MMC Expansion Project - Trees & Landscape

Thu, Nov 1, 2018 at 8:53 AM

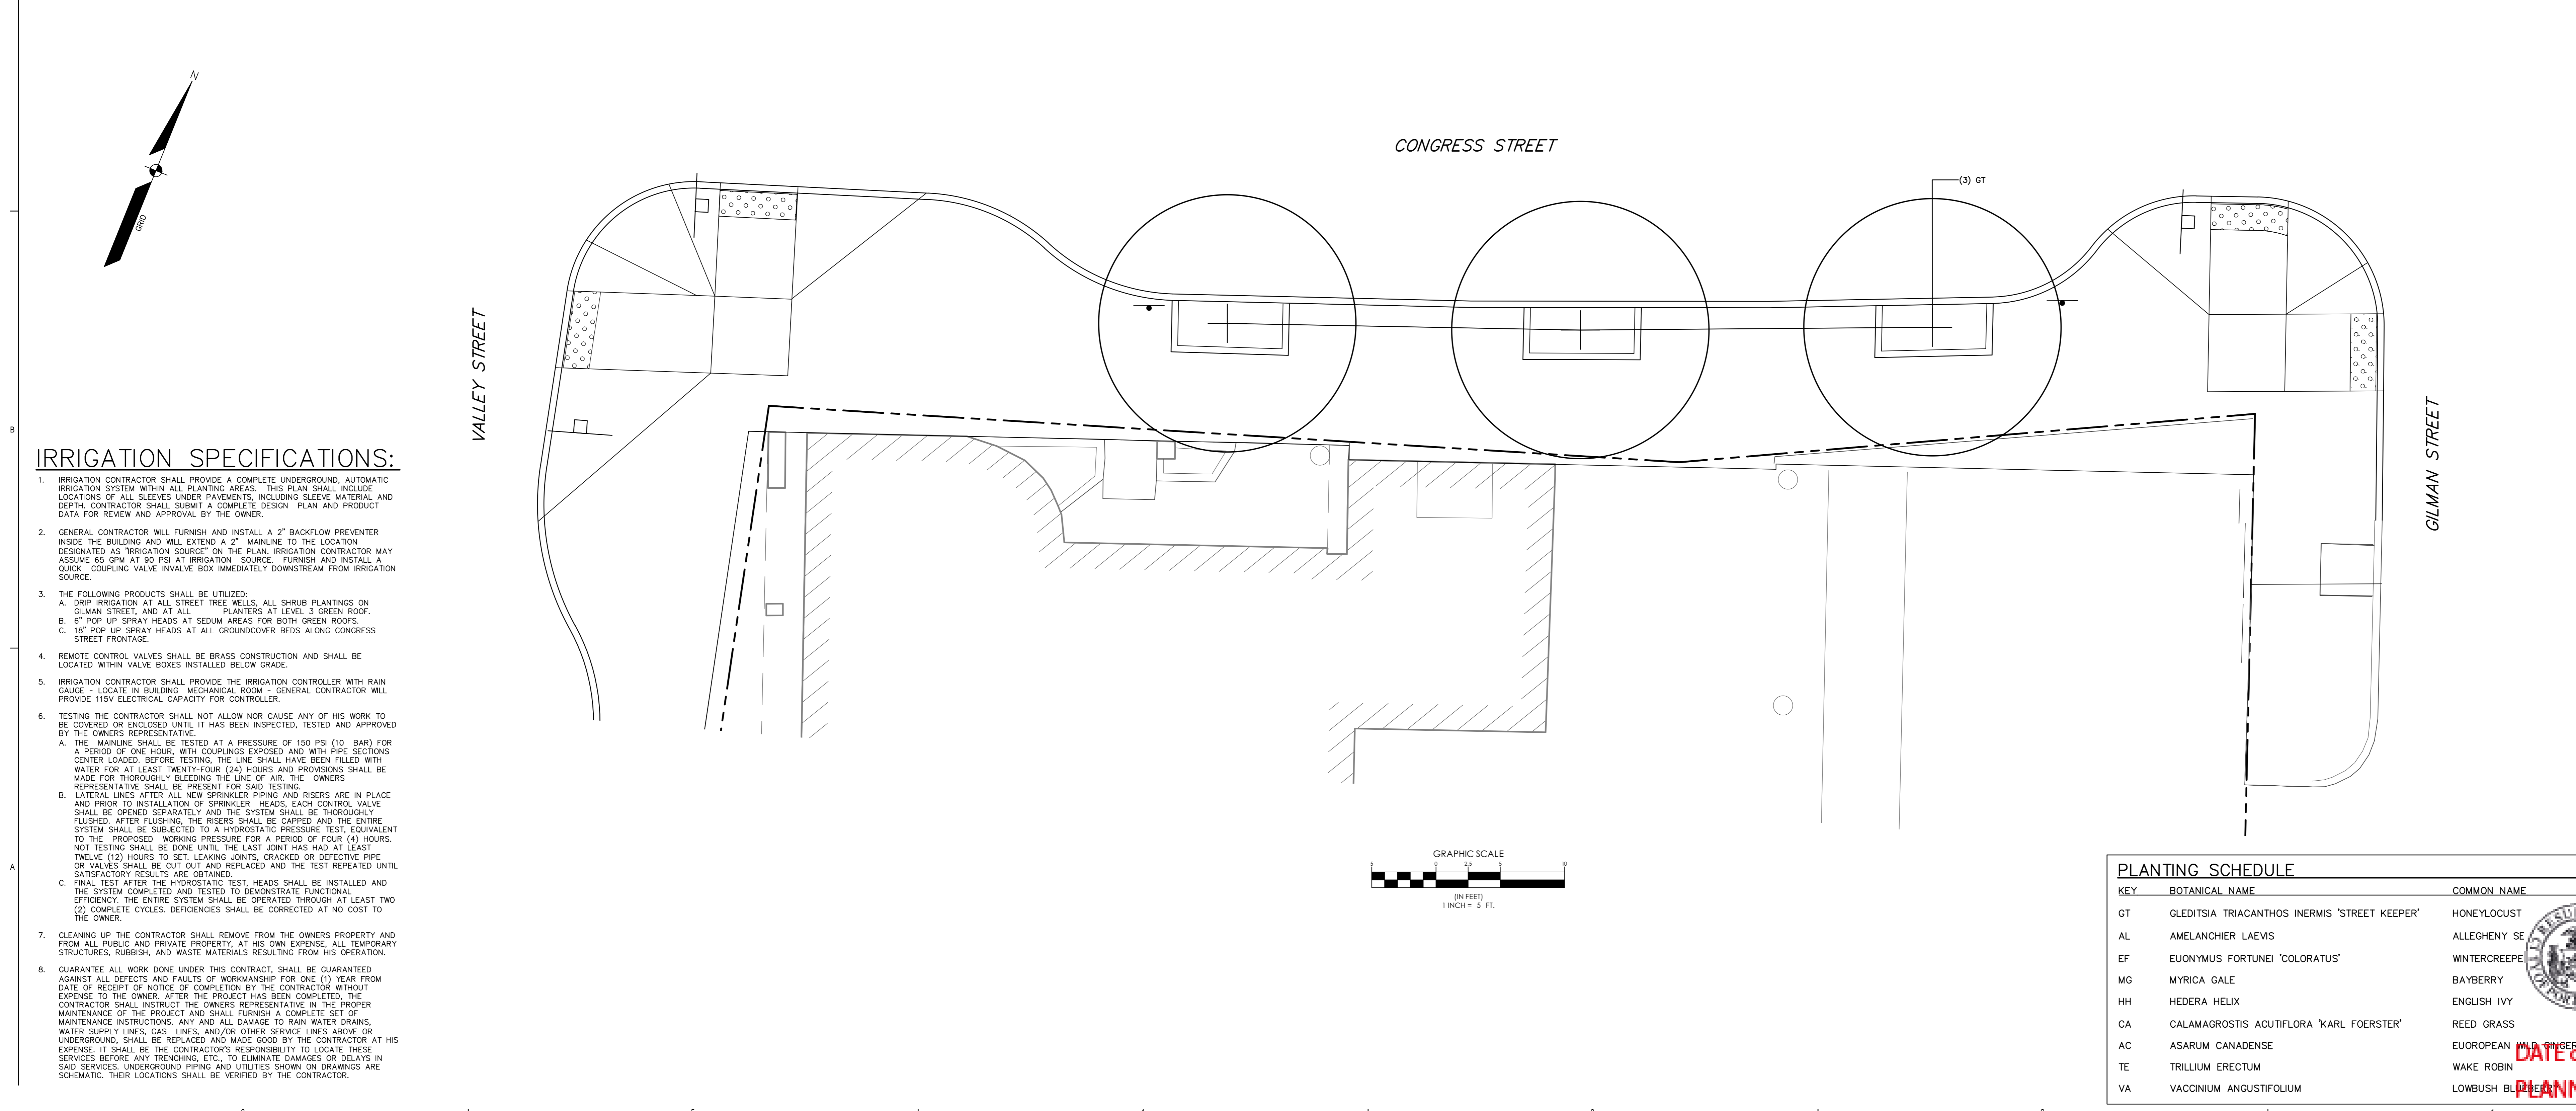
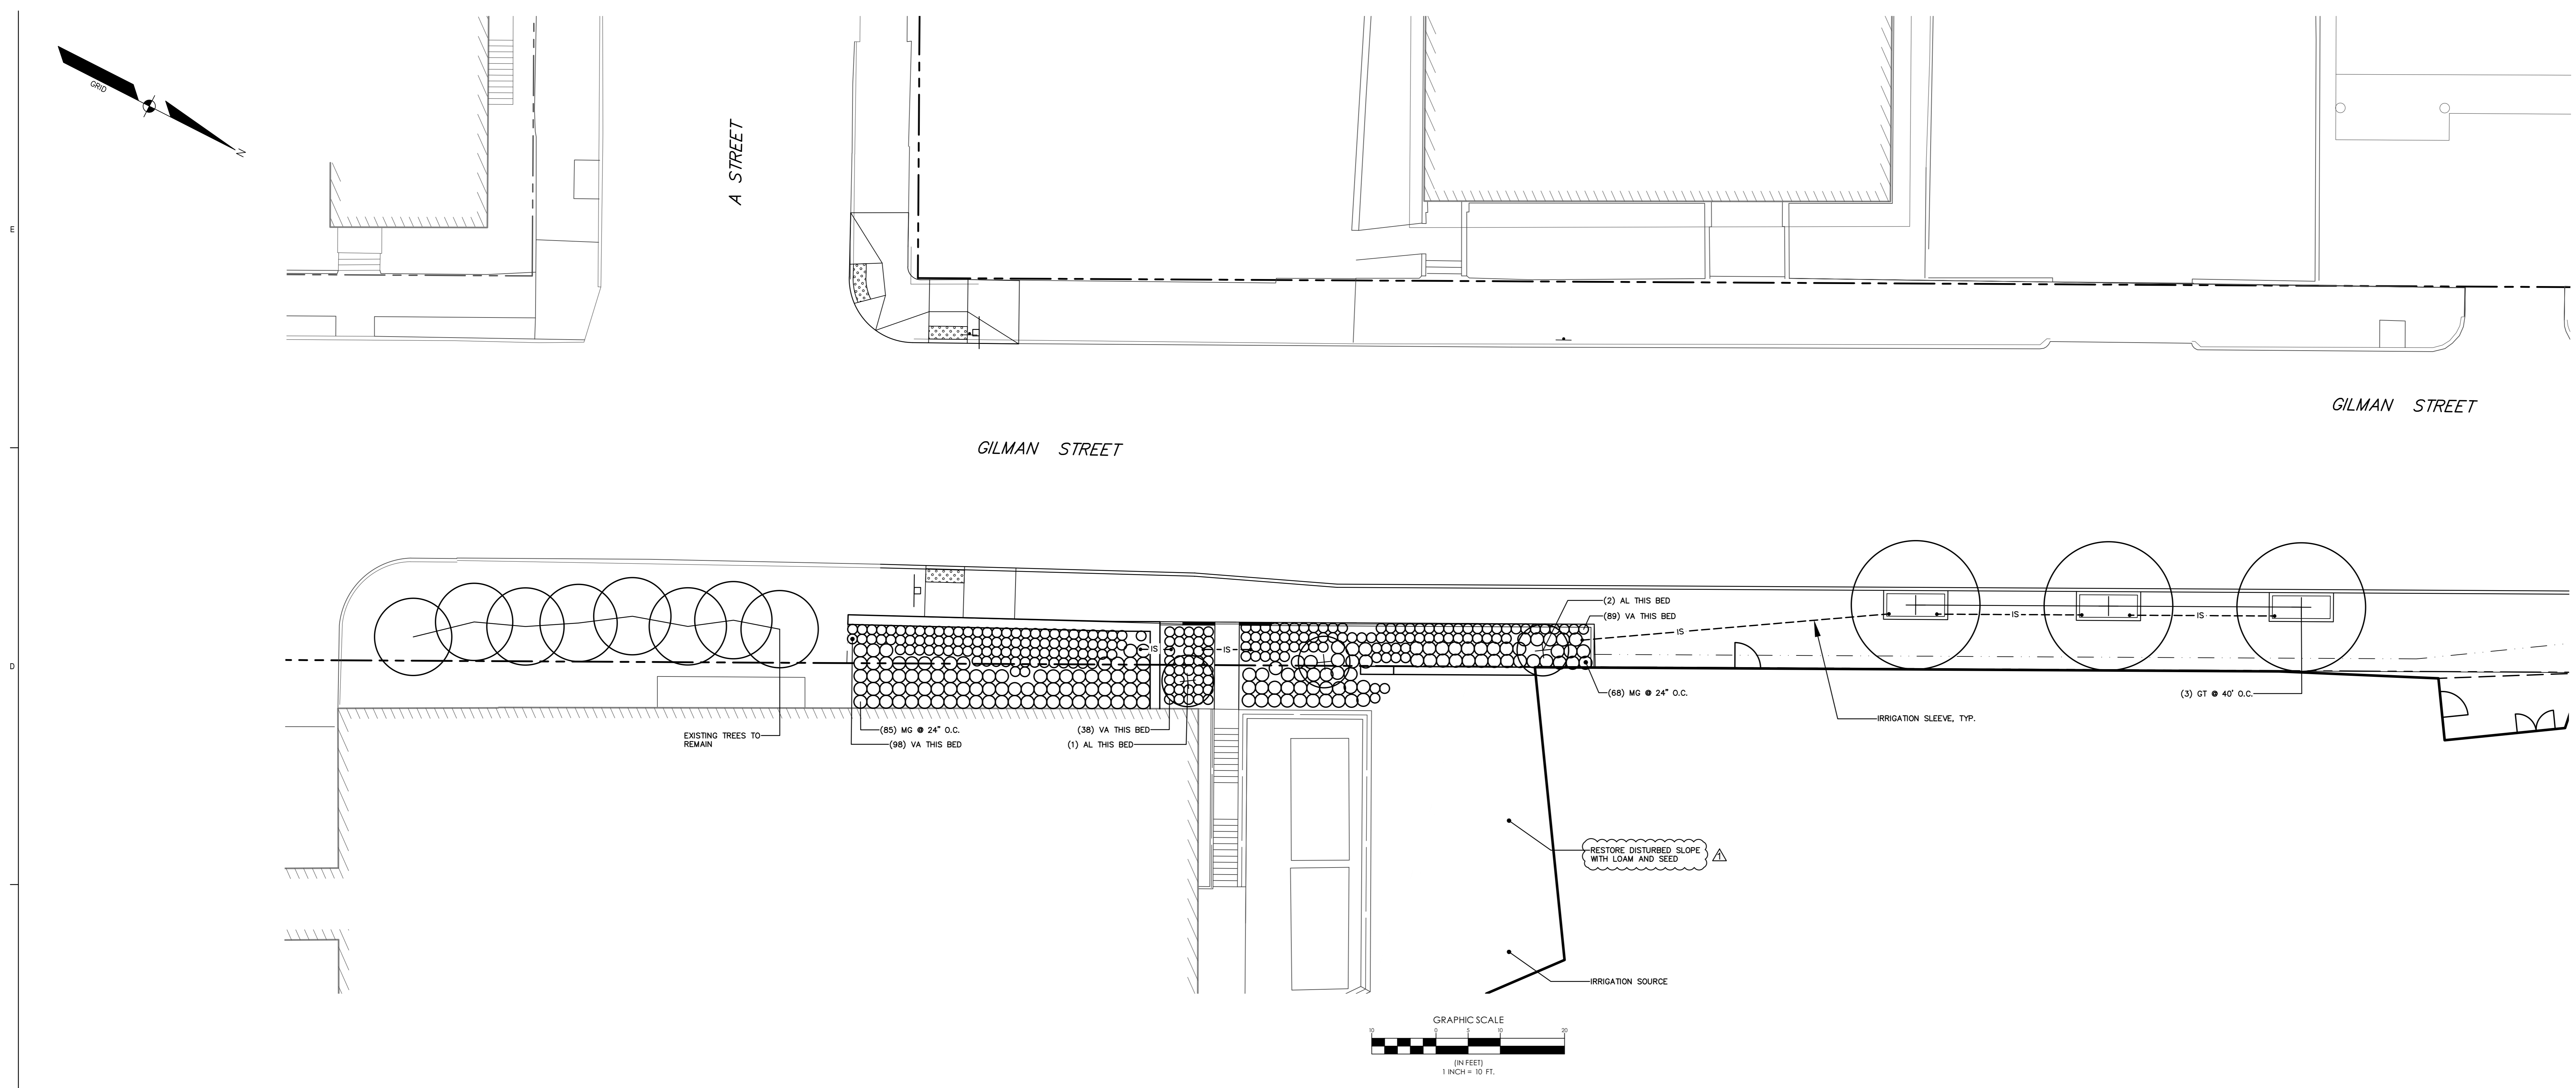
Wanted to see if we could meet up or we can discuss via email the tree and landscape plan for the Maine Medical Center project. We would like to see when possible a higher degree of 'native' plant types in our city landscapes. The use of 'native' plants and we know that this is a general term, should fit well into the overall MMC goal. Tree and landscape values could be an theme for MMC and future project that consider landscape greenery and how it relates to human health and well being.

Street trees - knowing that the project frontage will have a bus stop and bring in a tall vehicle close to the curb, a more upright cultivar of Honeylocust like the 'Streetkeeper' might be a good selection. 'Princeton' or 'Accolade' Elm could work as well. The web links below offer some comparison values on the attributes that can help select what works best for this site. (Open to other suggestions also)
